LAND TECHNOLOGIES, INC.

Response to Comments

Project Name: Undi Commerce Park
 Project File Number: PA 22008
 Review Completion: January 30, 2024

Frontage Modification Plan

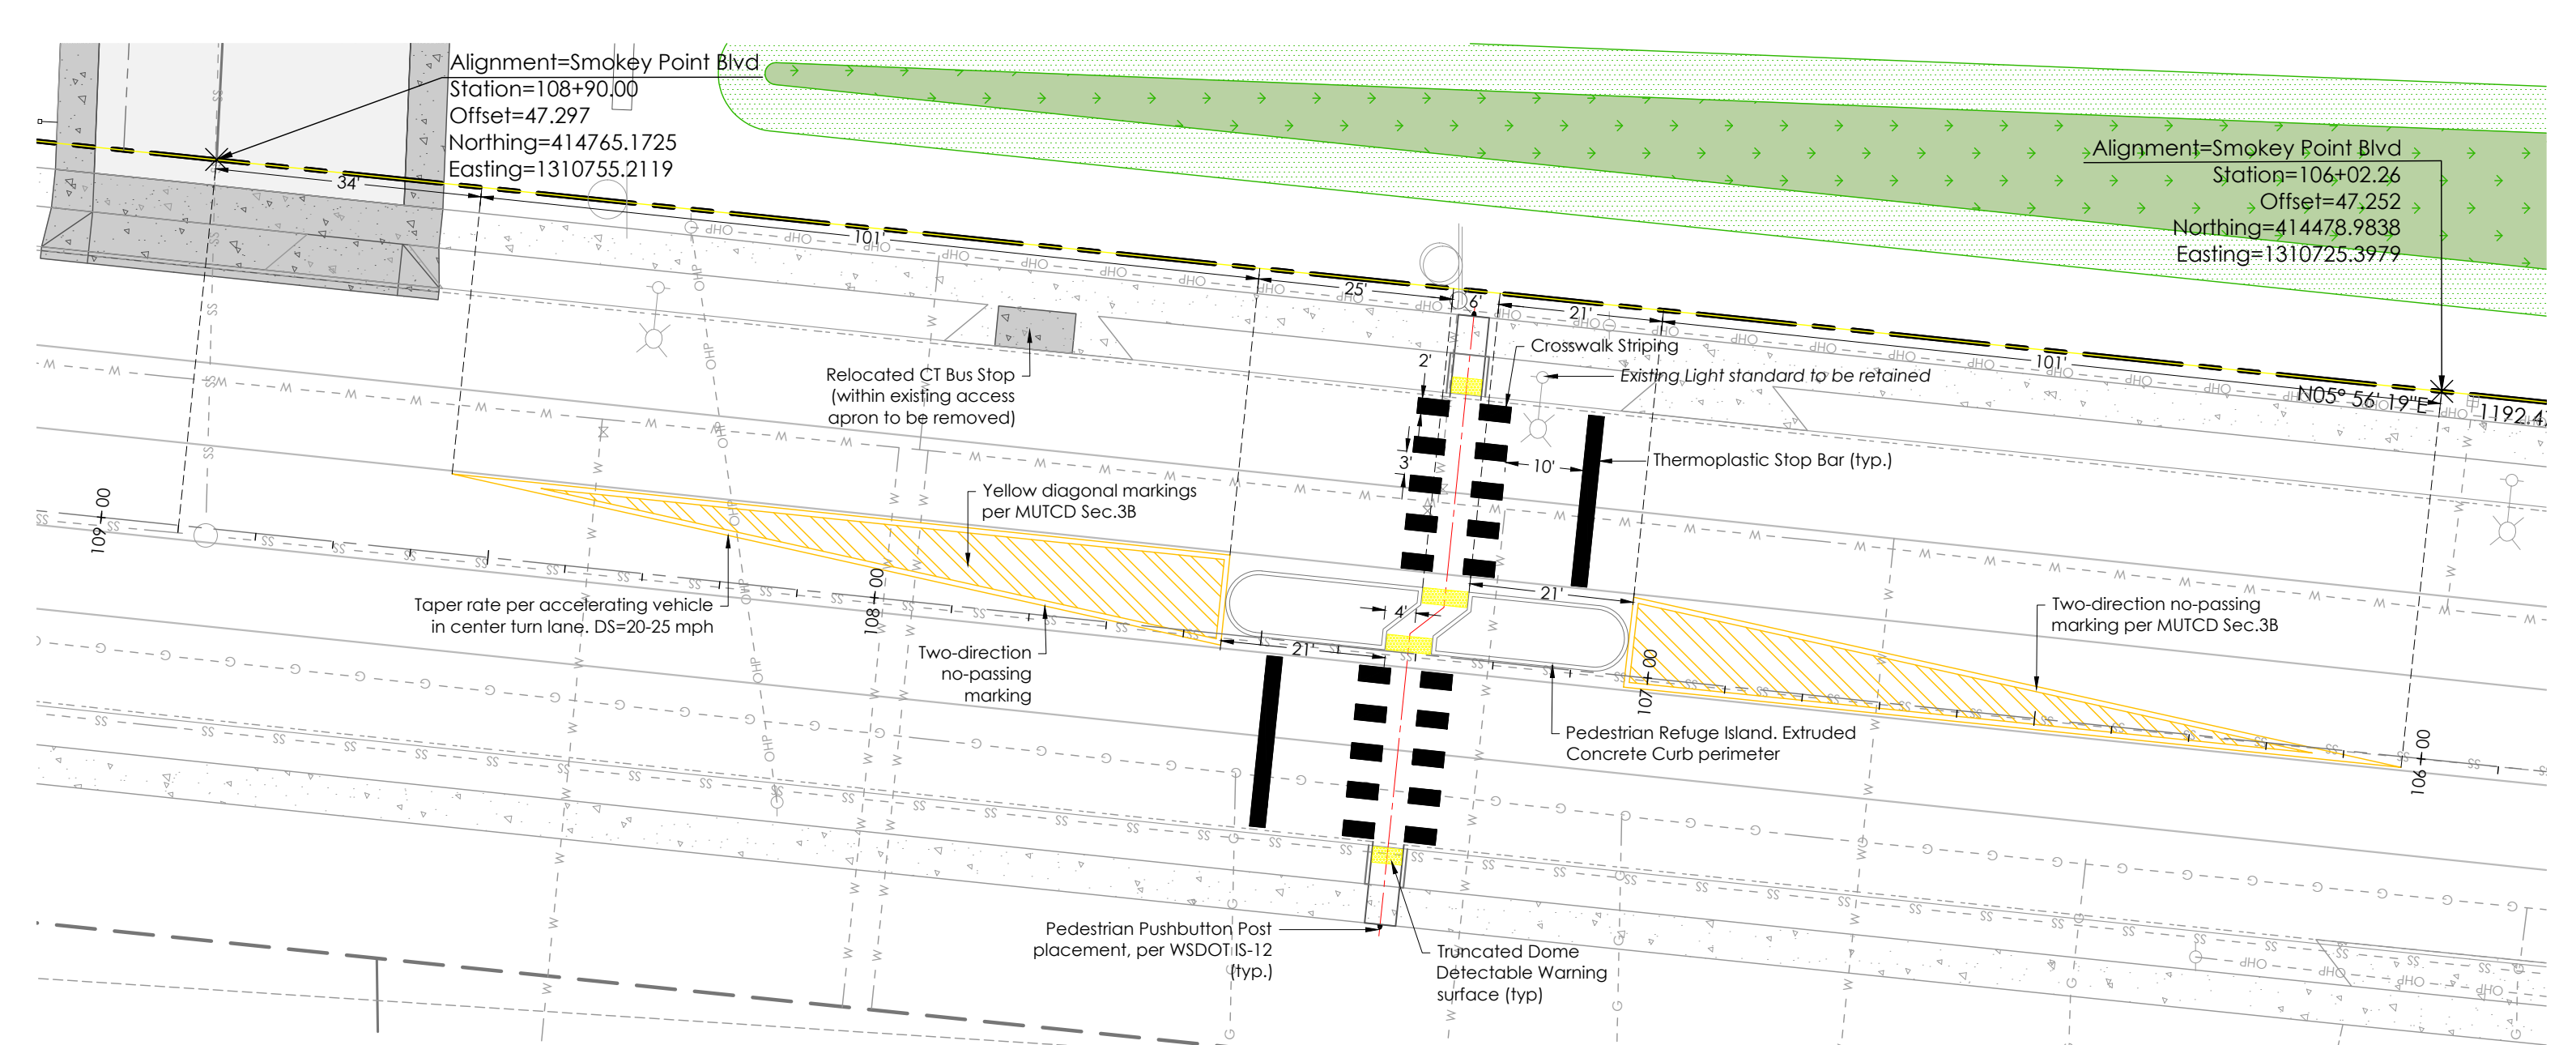
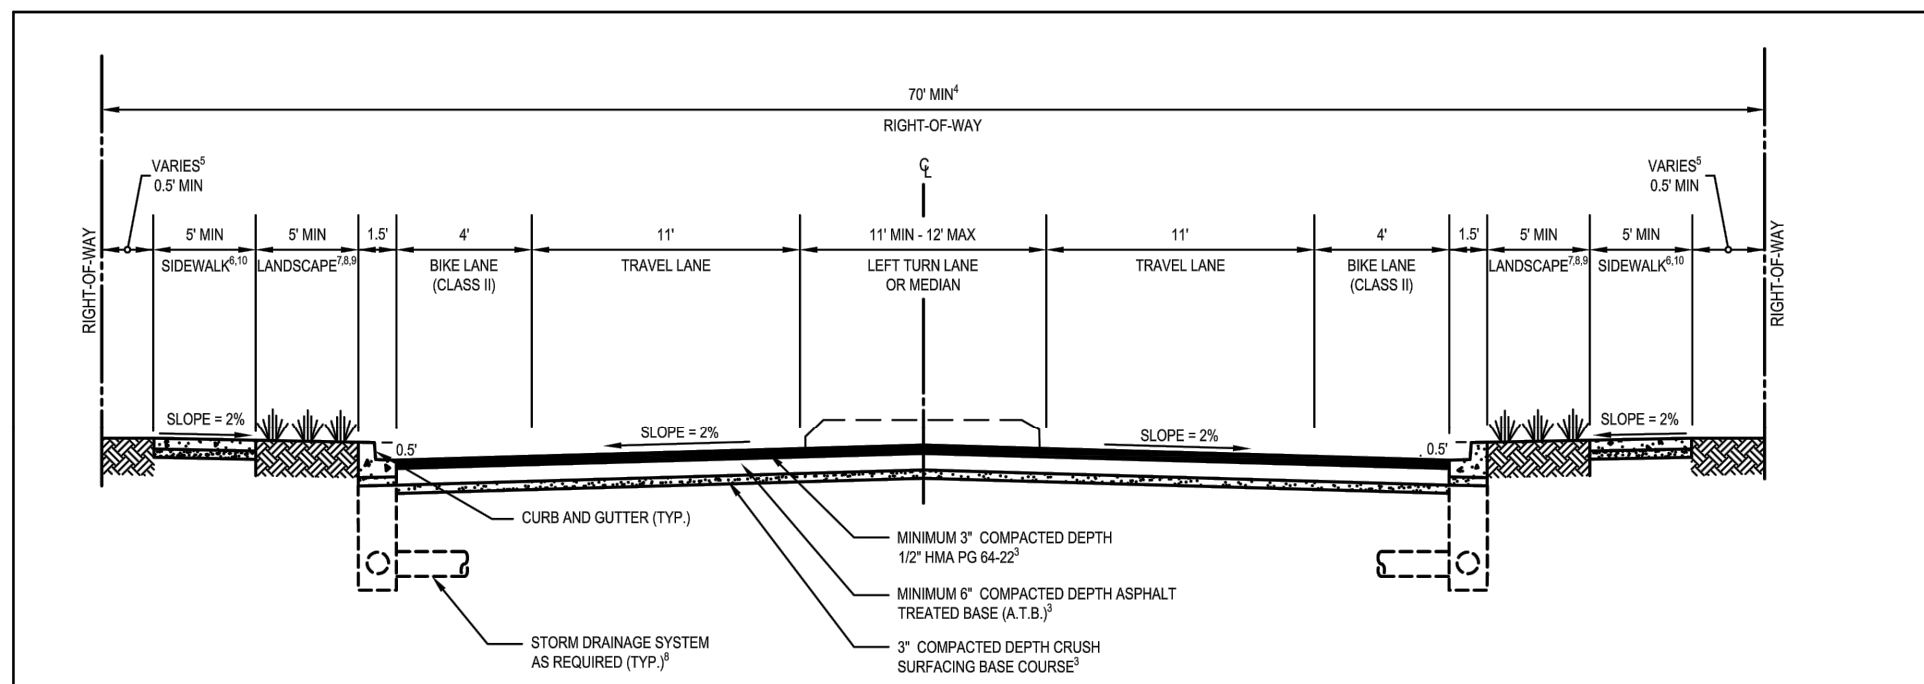
CITY COMMENTS	LAND TECH RESPONSE
<p>a. 152nd St NE, per the Comp Plan is designated as a Minor Arterial per EDDS Standard Plan 3-201-004.</p> <p>b. Plans must provide detail required to construct 152nd ST NE frontage improvements including Plan, cross-sections, etc.</p>	<p>35-ft of ROW, sidewalk, and “152nd St Frontage Improvement per Minor Arterial required”</p> <p>See Sheet C13 – 152nd St NE Frontage Improvement Plan</p>
<p>4. Per EDDS 3-301, Arterial Access Management Standards shall apply:</p> <p>a. Proposed southern shared access point aligns with northern unsignalized Marysville Fire District driveway with a span wire traffic signal installation.</p> <p>i. Access location is only 30-40’ from the existing traffic signal.</p> <p>ii. A deviation would not be supported by Public Works Traffic Division for a full access at subject location with a traffic signal as currently exists given the conflict between northbound Smokey Point Blvd. traffic and trucks exiting the Industrial Developments.</p> <p>iii. Public Works Traffic Division would potentially support a variance if the development were to provide for one of the following options:</p> <p>A. Modification of the existing traffic signal to include signalization of the proposed shared driveway within the signal layout.</p> <ul style="list-style-type: none"> <input type="checkbox"/> TIA would need to be performed to evaluate signal LOS assuming east/west split phasing with the east & west legs not aligned. <input type="checkbox"/> Existing span wire signal installation might need to be fully replaced and/or new signal poles with mast arms be installed to accommodate new signal heads necessary. <input type="checkbox"/> Channelization modification to Smokey Point Blvd. would be required. <input type="checkbox"/> Signal installation/modification would be required to meet current MUTCD and ADA guidelines. <p>B. The existing traffic signal would need to be reduced to an Emergency Fire Signal only by:</p> <ul style="list-style-type: none"> <input type="checkbox"/> Reconfiguring span wire signal heads to provide for fire signal operations only. <input type="checkbox"/> Relocating the existing pedestrian crosswalk contained within the traffic signal operations to the north or south with the installation of a marked two-stage offset mid-block crosswalk with RRFB systems. Fully 	<p>a. A new sheet titled Frontage Modification Plan details the RRFB and midblock crosswalk location and access driveway removal for unused access aprons. Existing span wire signal will be reconfigured for emergency operations only. Thank you. Further design details will be provided with civil construction plans.</p> <p>b. All access points and proposed access points are located on this new sheet (Frontage modification Plan) Access locations are provided directly opposite of the west driveways where practical. Access location of the center Undi access is provided so that opposing traffic making a left turn on to Smokey Point Blvd will not cross paths as indicated with the concept vehicle markers on the Frontage Modification Plan.</p> <p>c. All existing curb cuts/driveway aprons will be removed.</p>

CITY COMMENTS	LAND TECH RESPONSE
<p>built-out Pedestrian Median Refuge Island will be required with pedestrians having a 2-stage RRFB system with a non-direct through pedestrian path to encourage viewing of oncoming traffic. (See example at Grove ST & Bayview Trail west of 81st DR NE).</p> <ul style="list-style-type: none"> <input type="checkbox"/> CT Bus Stops on both east and west side of Smokey Point Blvd. will need to be relocated to be near relocated crosswalk with RRFB. <input type="checkbox"/> Location of proposed pedestrian crosswalk with RRFB shall be located to provide for the least negative impact to utilization of the existing two-way left turn lane. <p>b. Spacing of access points must meet access management standards. Access points shall align with existing access points on the west side of Smokey Point Blvd. or meet access management standards. Show west side access points on site plan and civil construction plans. A deviation may be required depending on locations of existing west side access points.</p> <p>c. Existing curb cuts on property frontage which are not to be utilized, shall be removed and replaced with roadway standard landscape strip and sidewalk</p>

**3-LANE ARTERIAL BICYCLE CONFIGURATION**

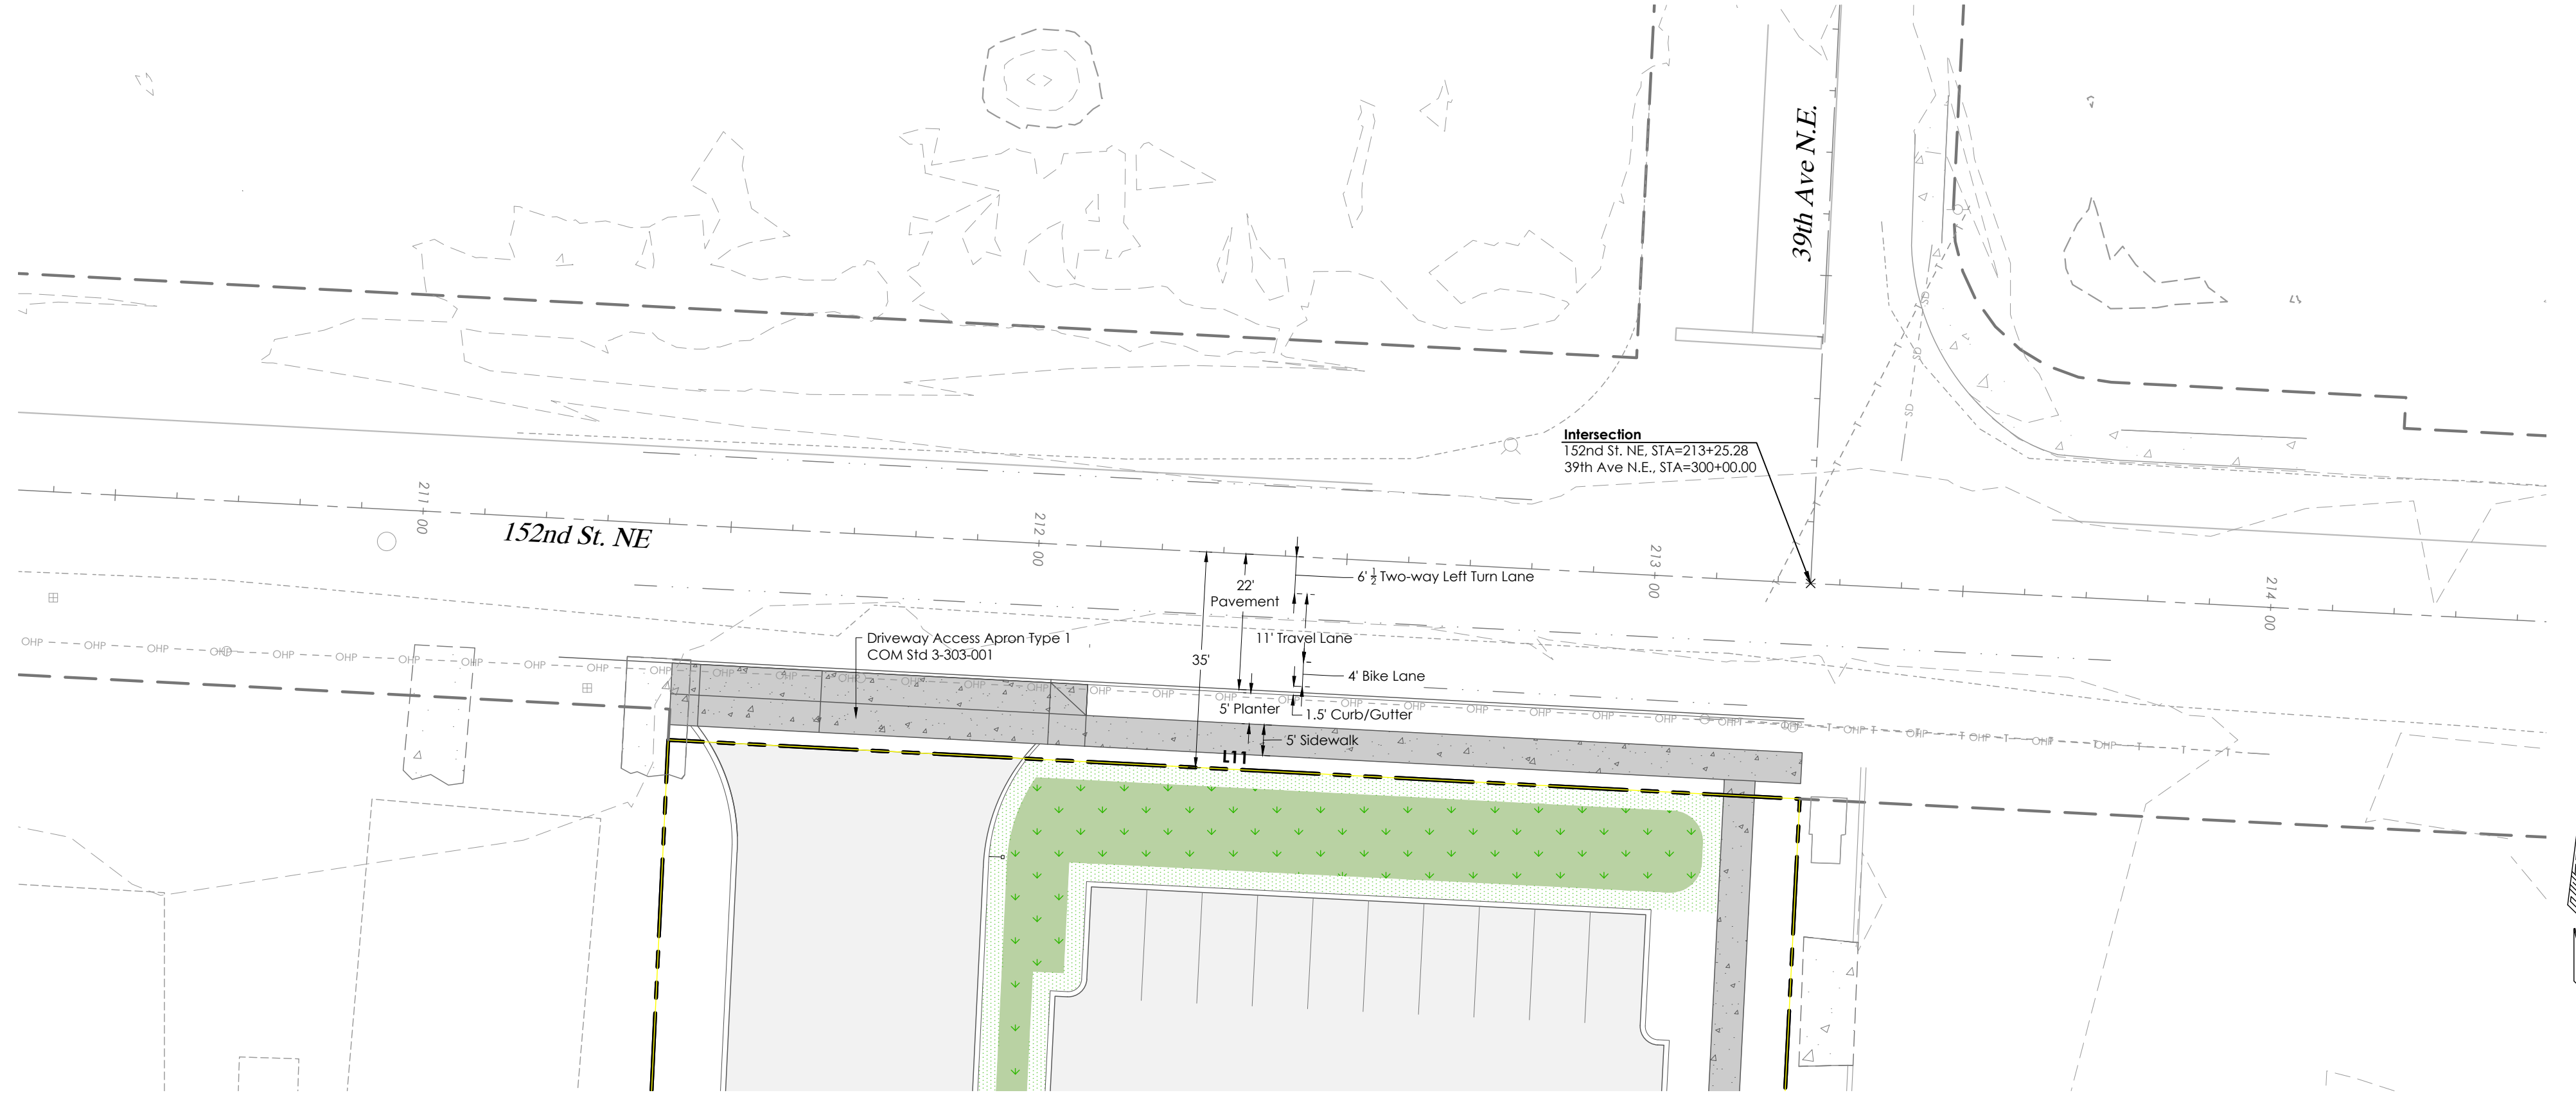
3. Frontage improvements including street lighting as well as ROW dedication may be required, specifically but not limited to, on 152nd St NE.	Thank you. Full Frontage improvement plan will be provided with construction plans. C1- Civil site plan denotes 152 nd St NE as a Minor Arterial. Annotation on this sheet requires Pavement width of 22-ft per EDDS 3-201-004,
